Your ref: EN010132

Date: 05 June 2023

Order Granting Development Consent for the West Burton Solar Project (EN0101320)

2.2 We have reviewed the DCO, Environmental Statement (ES) and supporting documents submitted as part of the above-mentioned application, which we received on the 18 April 2023. Our comments are presented below:

Figure Reference	Page	Description of Changes	Reason for Revision
WB6.4.4.1_A Figure 4.1 Illustrative Site Layout Plan West Burton 1	3	Addition of River Till Flood Storage Area to plan	Requested by the Environment Agency in their Relevant Representation reference: <b>[RR- 090]</b> .

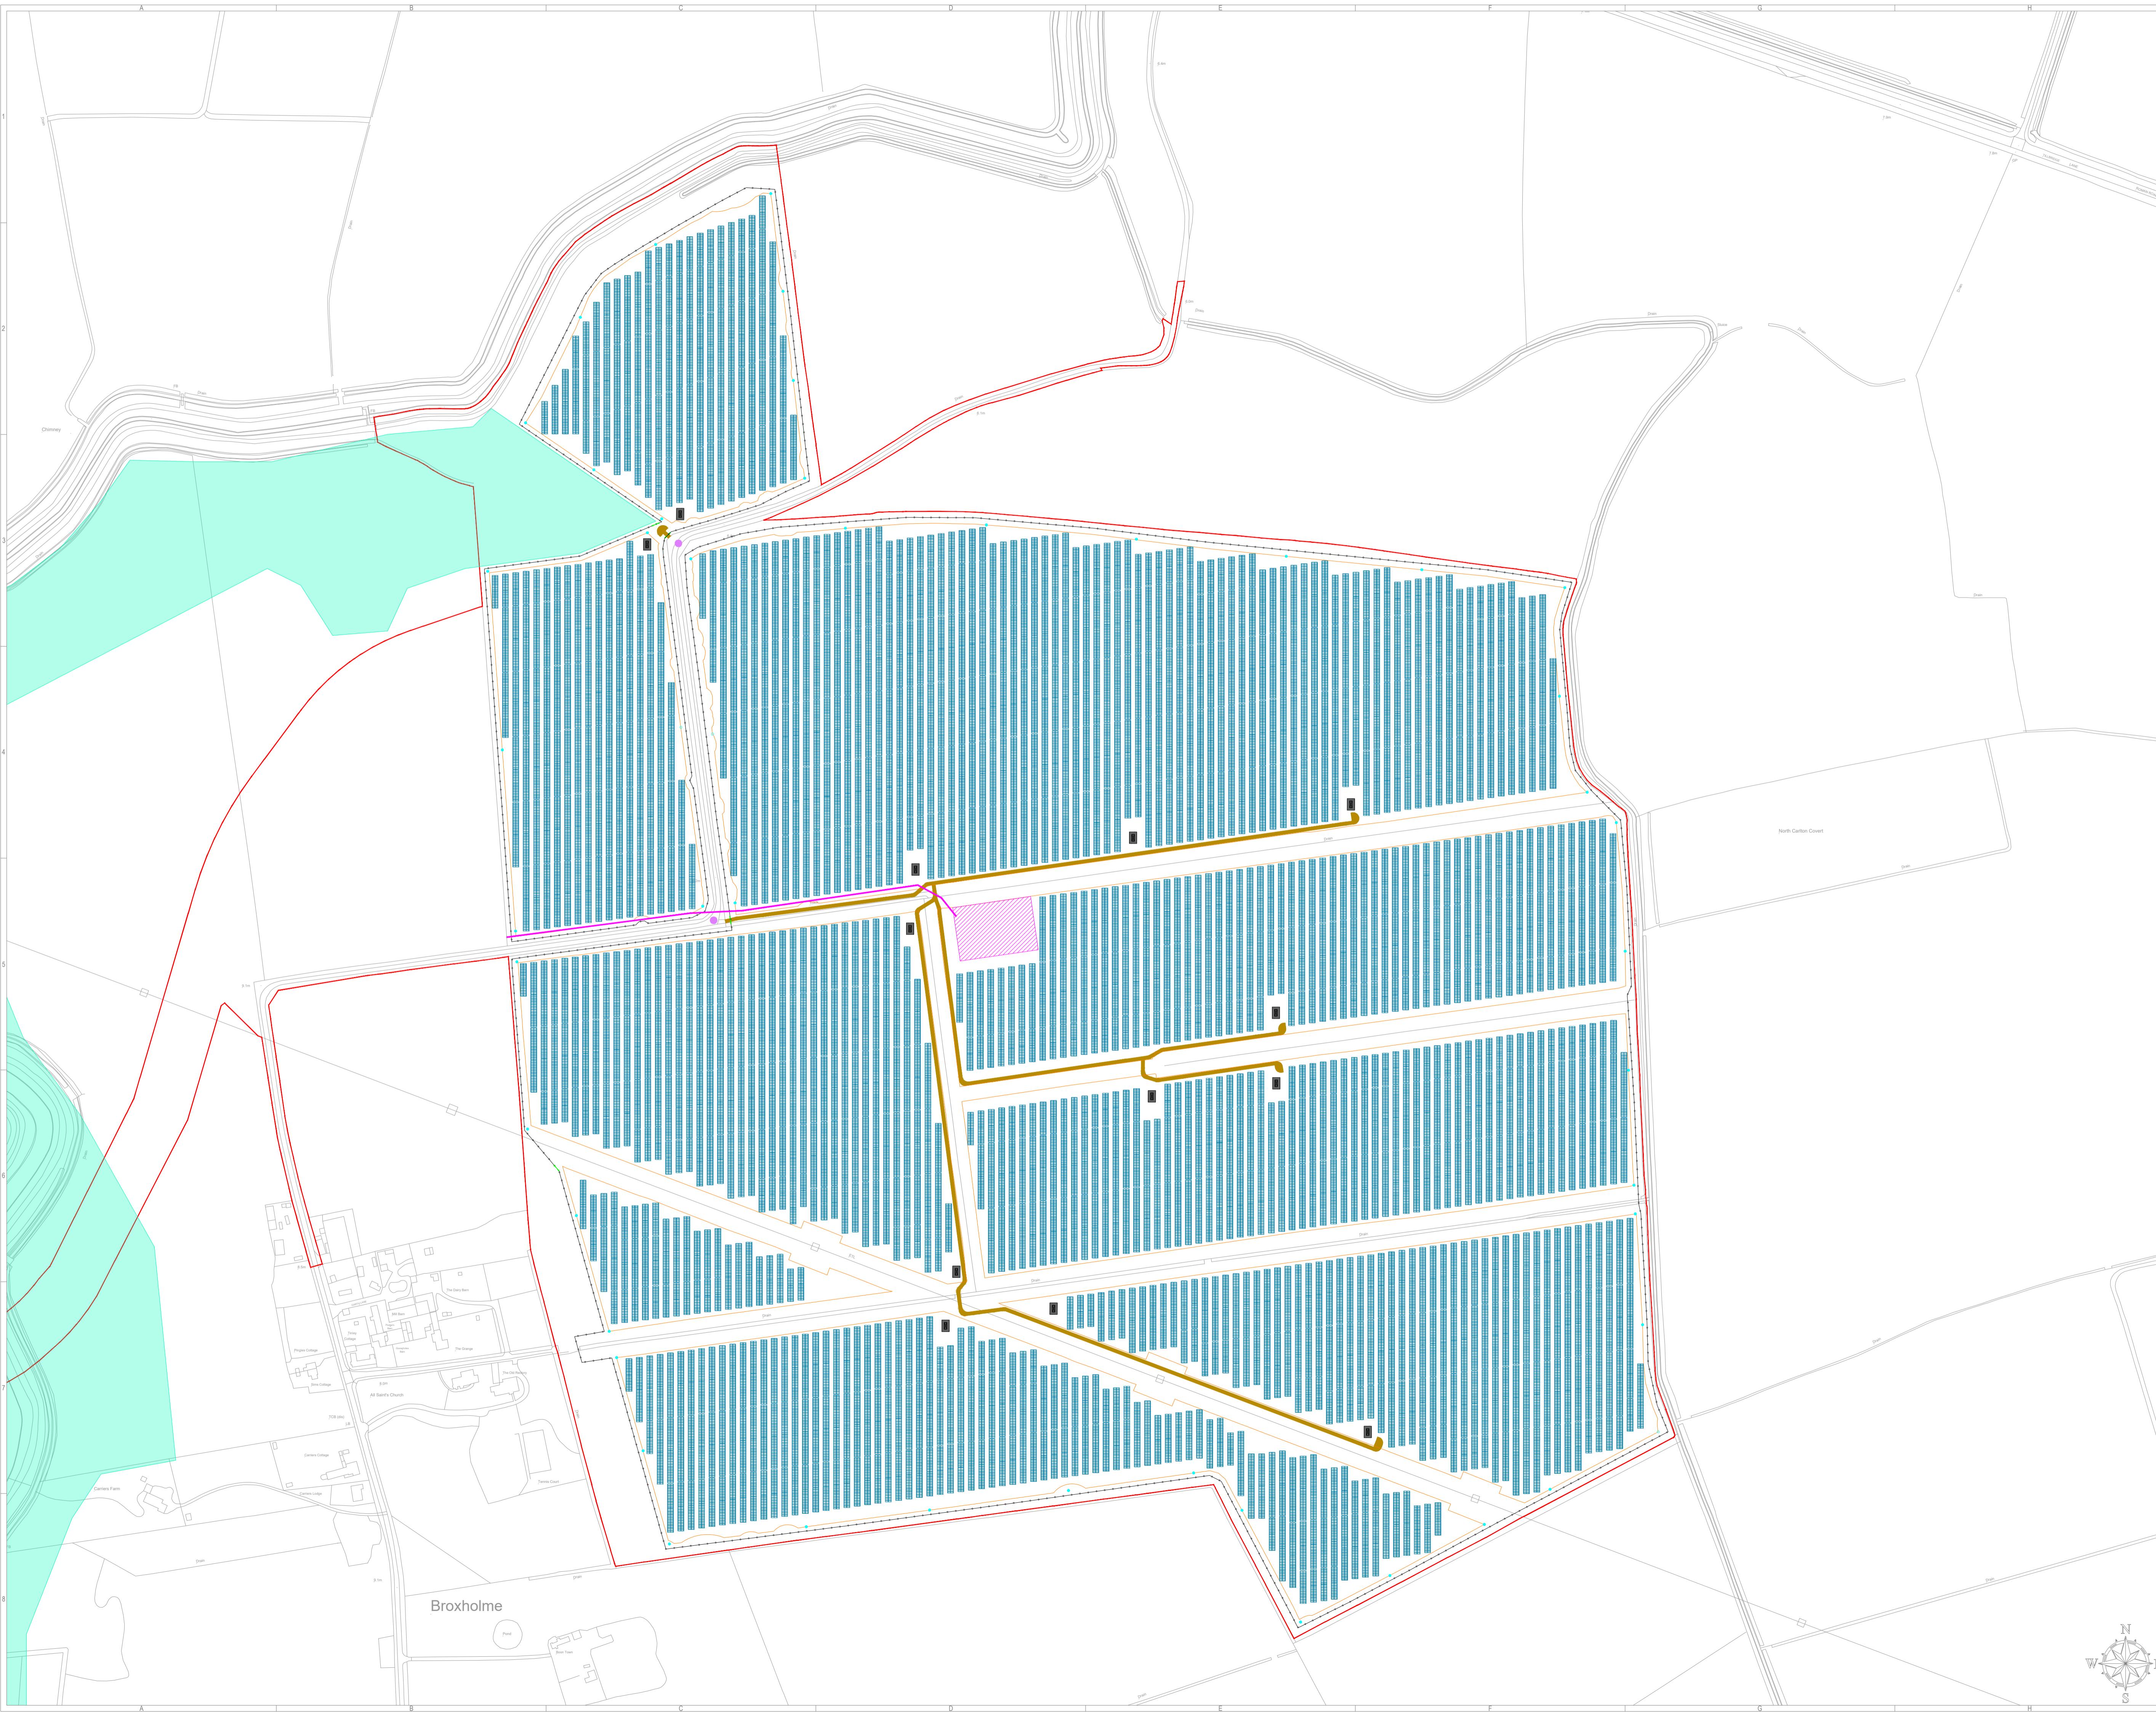
- 4.4 It is understood that no development will be situated within the River Till Flood Storage Area (FSA). For the avoidance of doubt we would ask that the applicant overlay the River Till FSA outline onto the illustrative site layout plan and include it within Appendix 10.5 of the ES.
